AMENDED PLAN

DEAR Ms. BOWEN,
TOWN PLANNING : LAWFUL DEVELOPMENT APPLICATION FOR USED
CONVERSION AT 14 WEST HATCH MANSION, REVISIT.
YOUR REF : 2006/2602

Dwg No. PW/WHM/02 Rev.

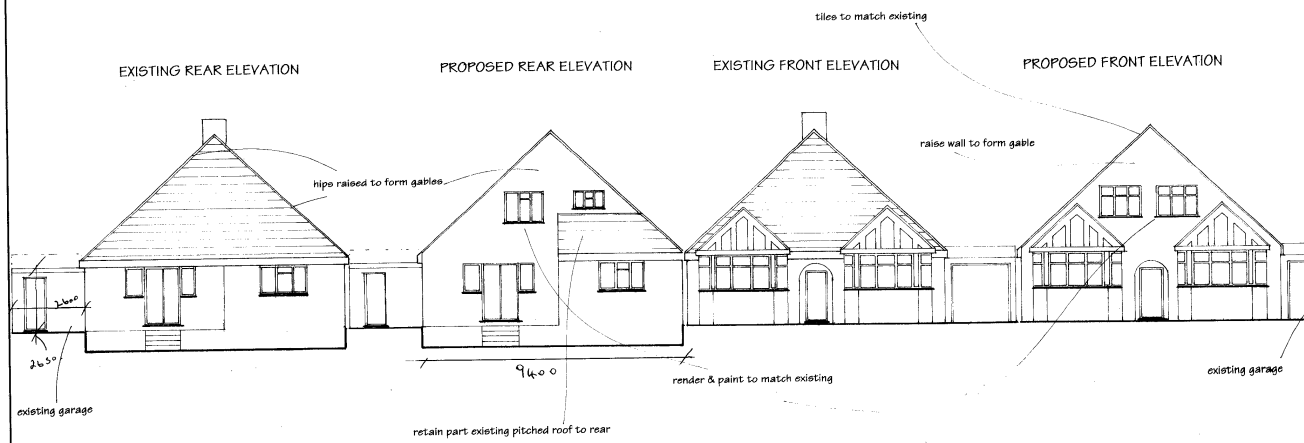
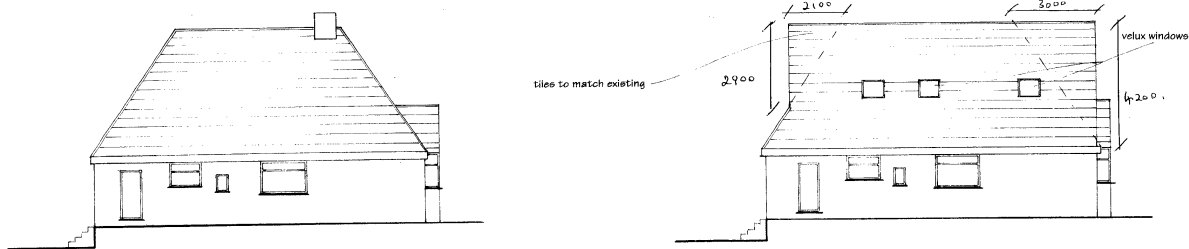
WITH REFERENCE TO THE ABOVE APPLICATION PLEASE FIND ATTACHED
4 COPIES OF REVISED PLANS FOR THE ABOVE PROPOSALS.
THE EXISTING SMALL PITCHED ROOF OVER THE ROAD 'CANOPY' AREA
IS NOW TO BE RETAINED.

THIS HAS NO EFFECT ON THE VOLUME CALCULATIONS SUBMITTED
AS THIS WAS NOT INCLUDED IN THE CALCULATIONS + IS PART OF
THE EXISTING ROOF.
